**New Wee Waa High School (SSD-21854025)  
Request for additional information**

I refer to the Department of Planning and Environment's (Department) Request for Information (RFI) dated 29 April 2022 and the Supplementary Response to Submissions (SRtS) received 30 June 2022 in response to the RFI. The Department has reviewed the SRtS and referred it to Narrabri Shire Council (Council) and the Department's Biodiversity, Conservation and Science (BCS) Directorate.

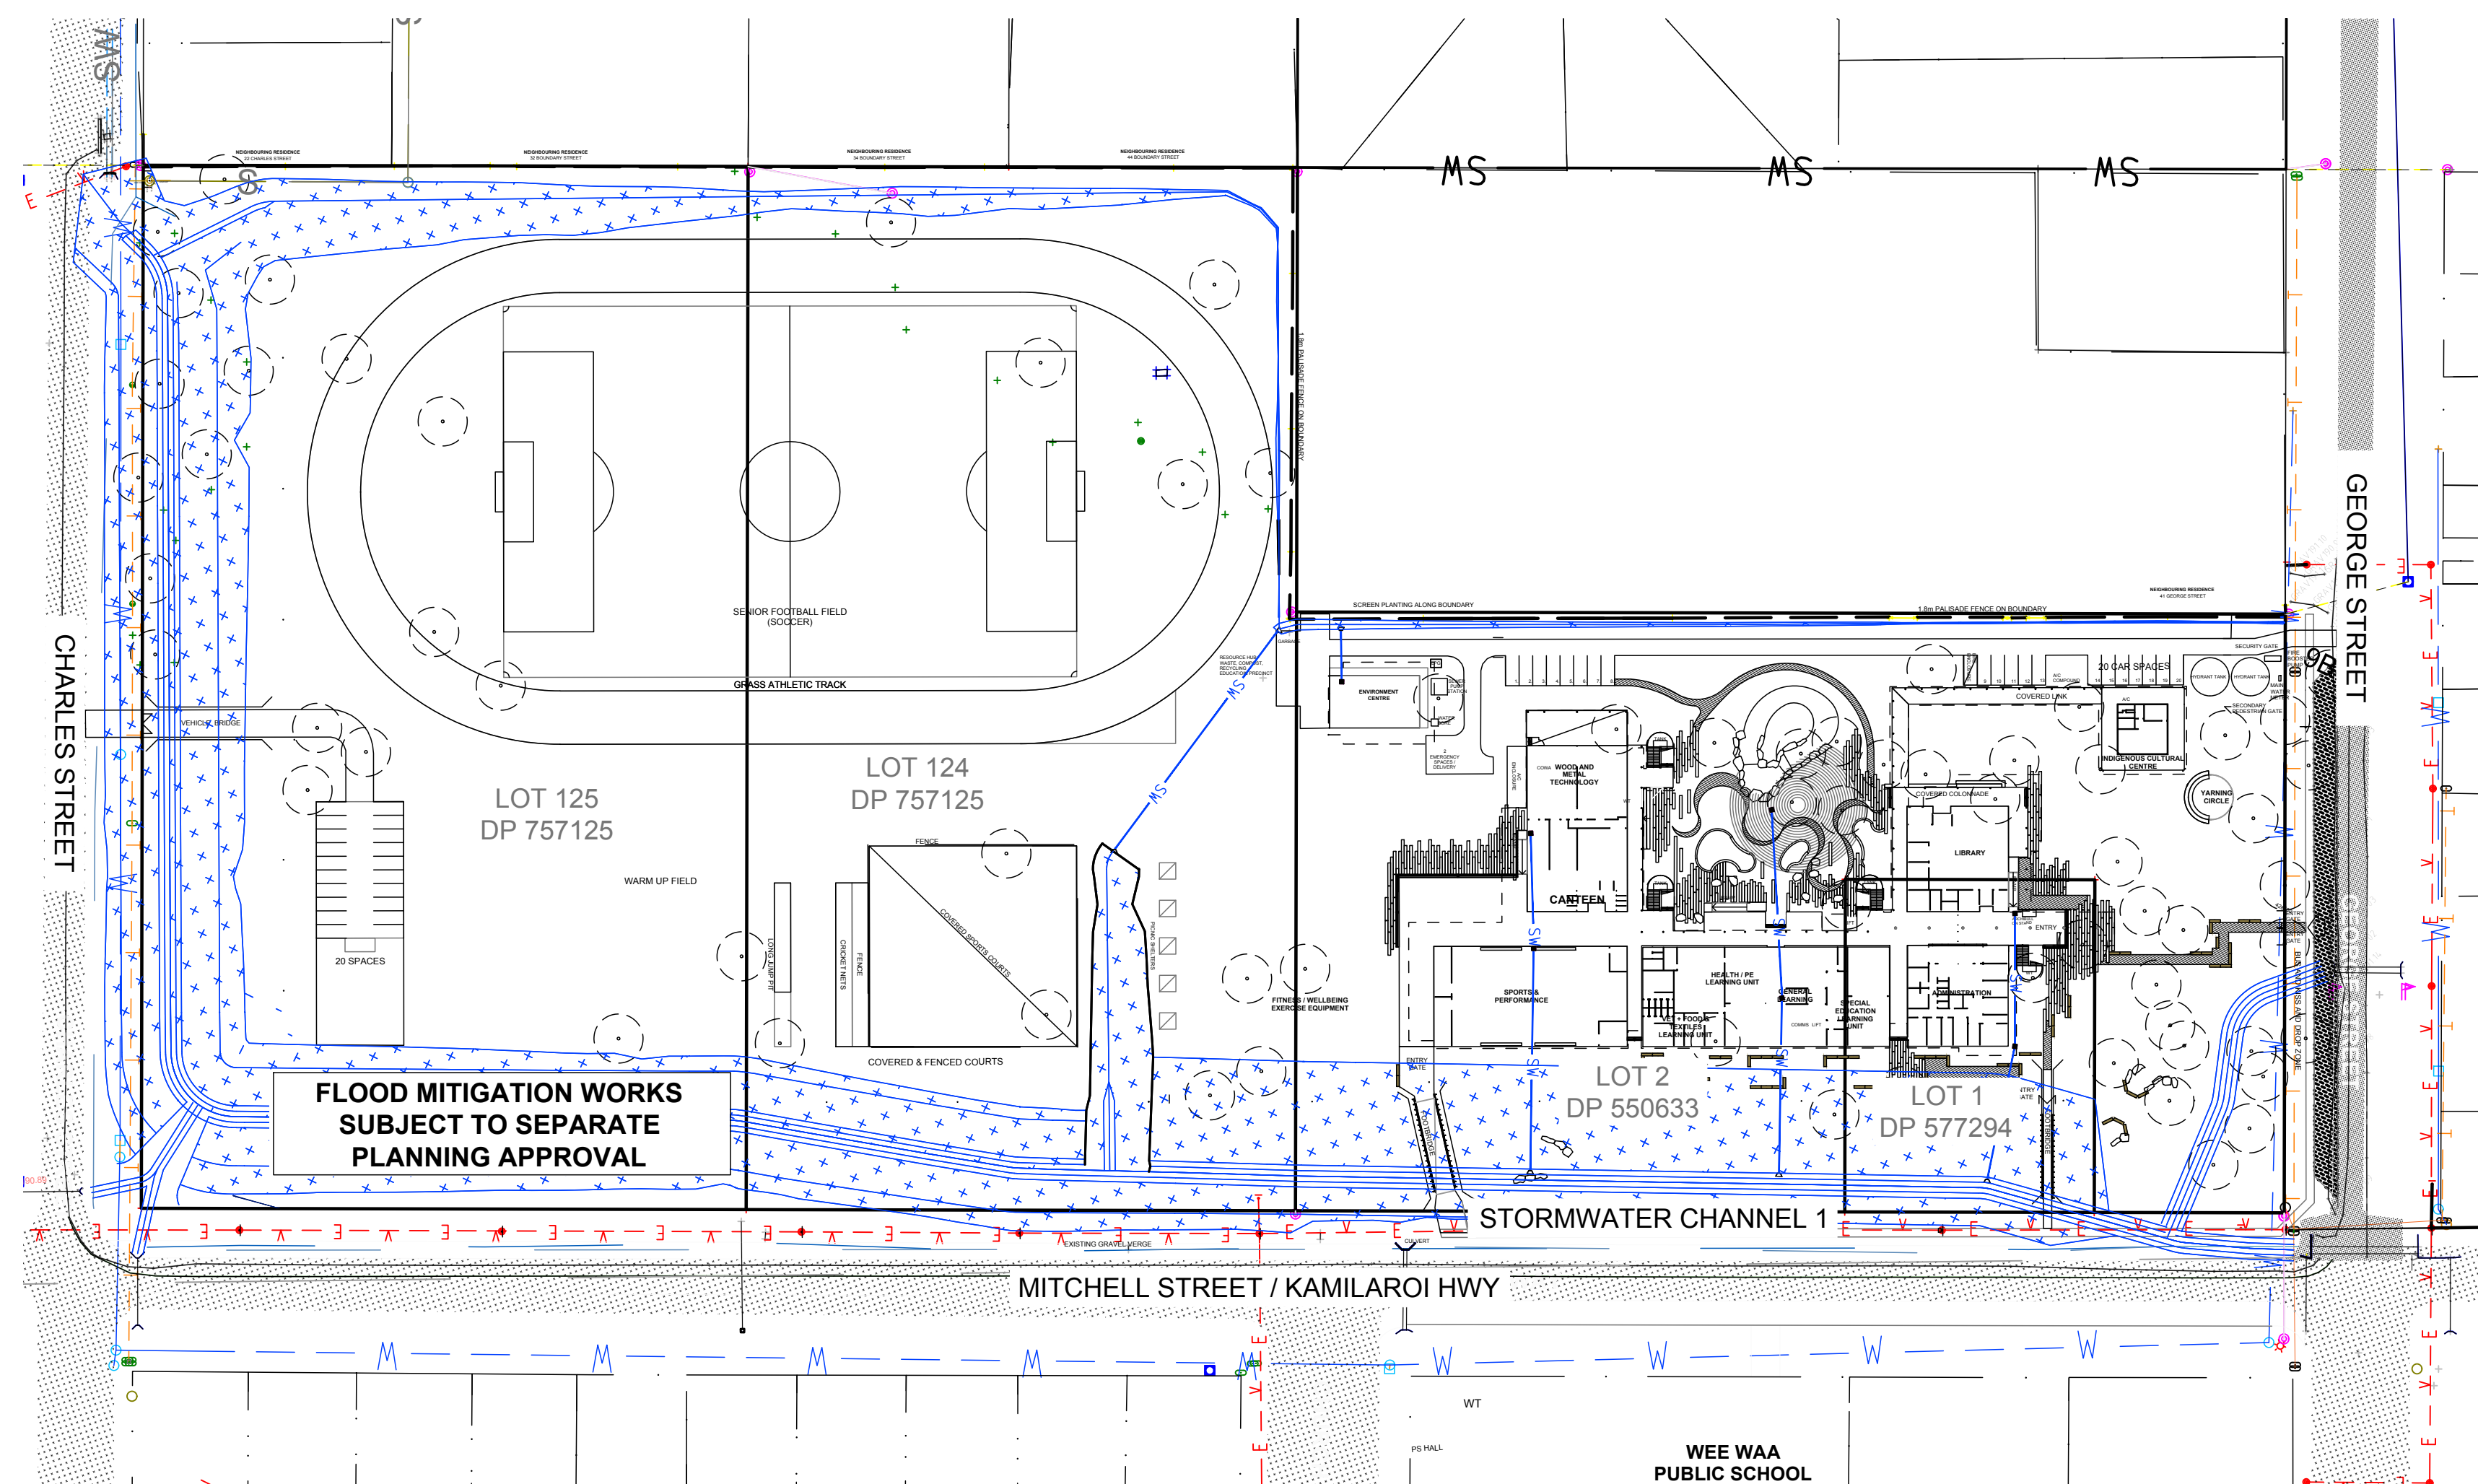
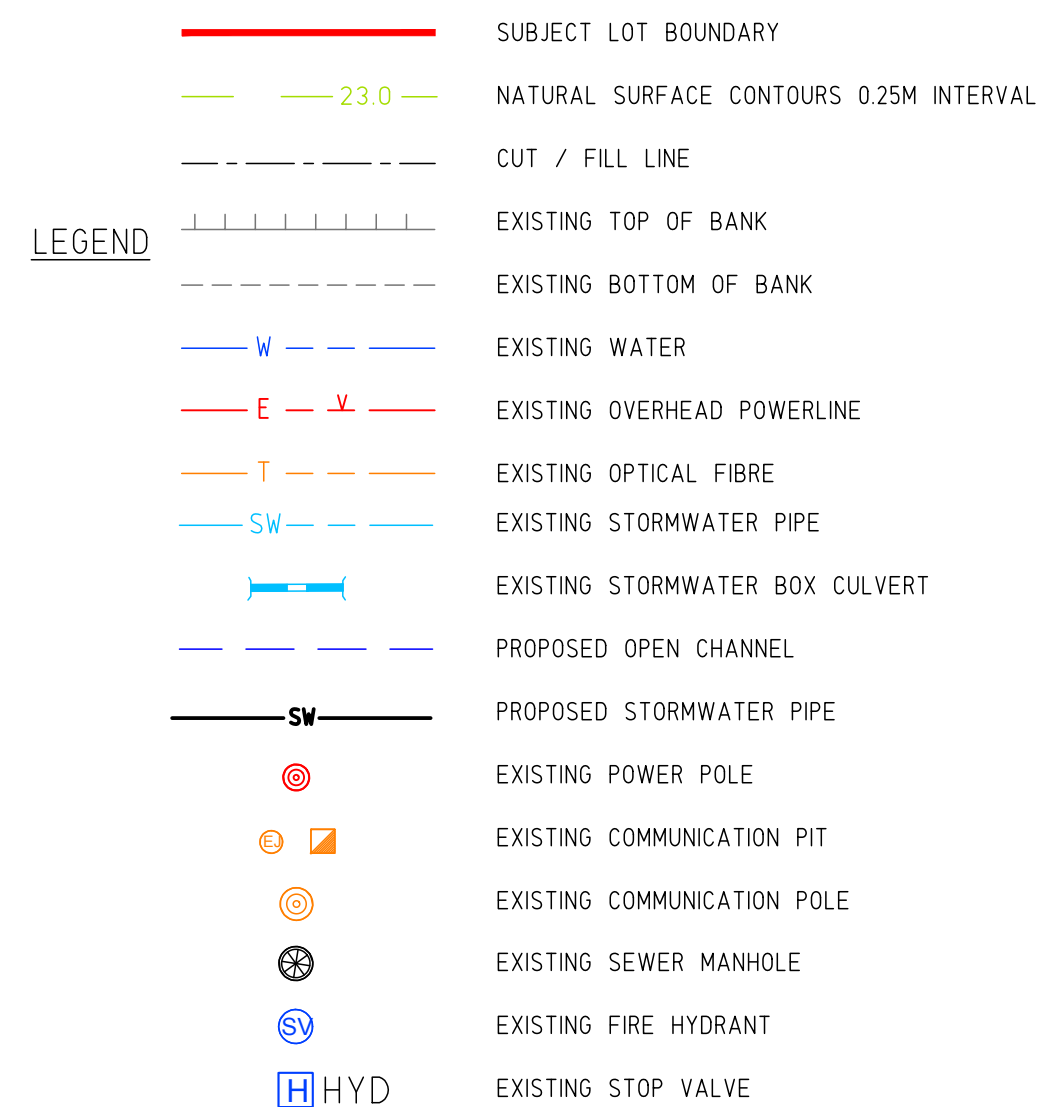
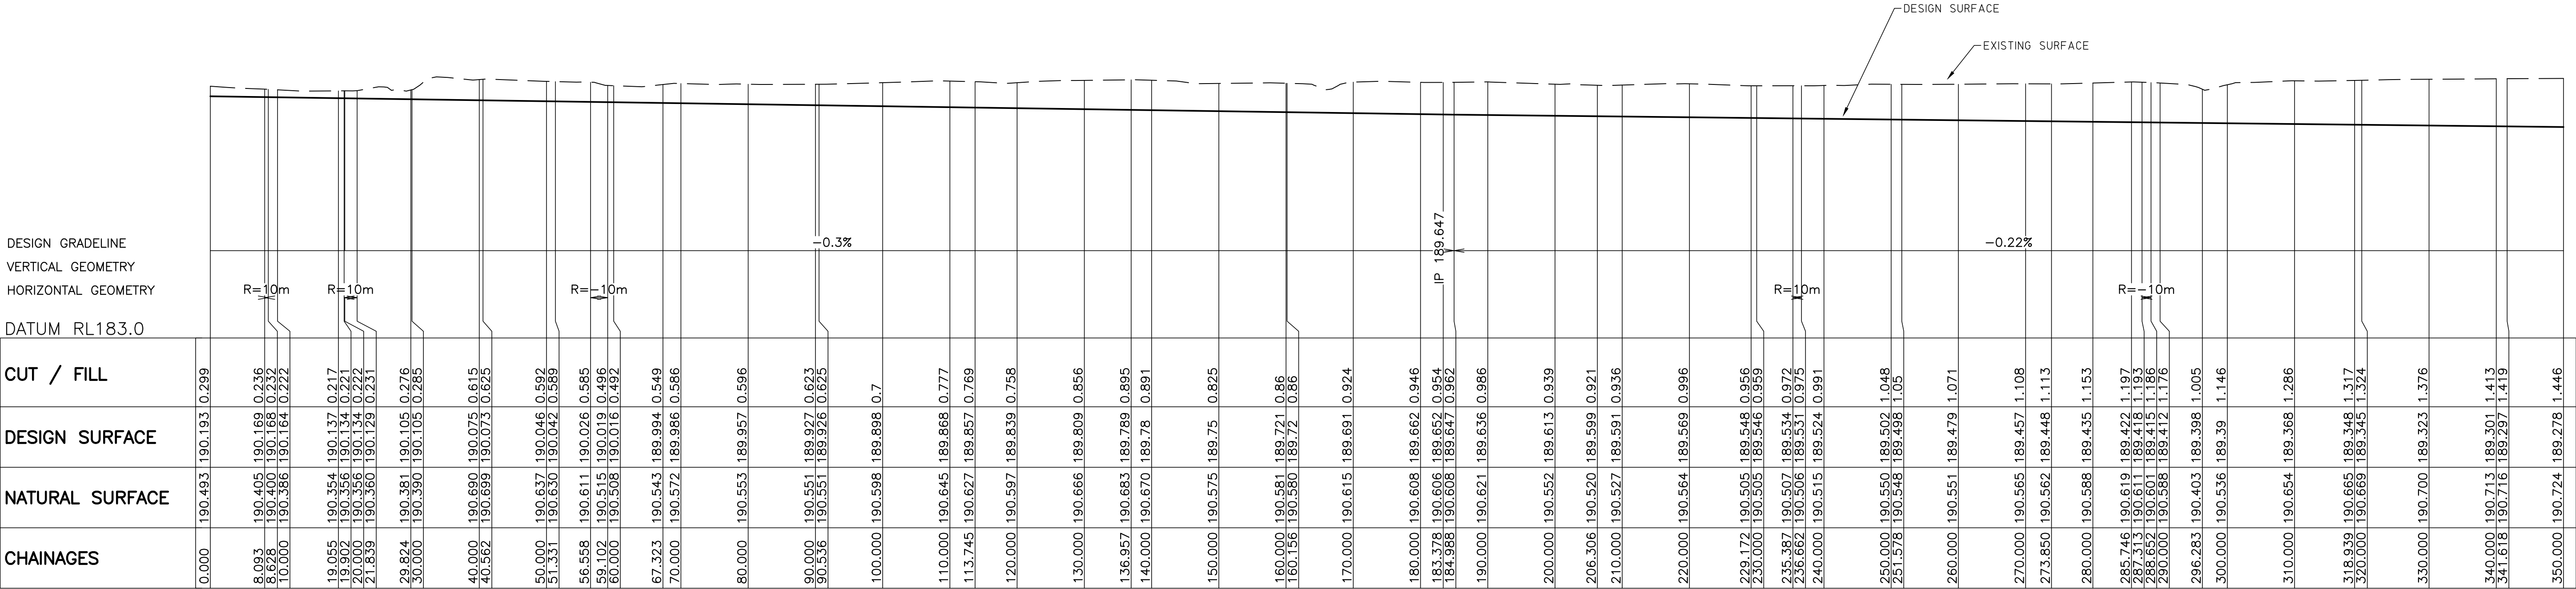
- a) Specify what drainage and flooding works that specifically form part of the SSD application. The Department has reviewed the civil drawings and it appears that only two channels are proposed on the site together with stormwater pipe infrastructure. Attachment 3 highlights what appears to be proposed as part of this application. Please review this and confirm / clarify.
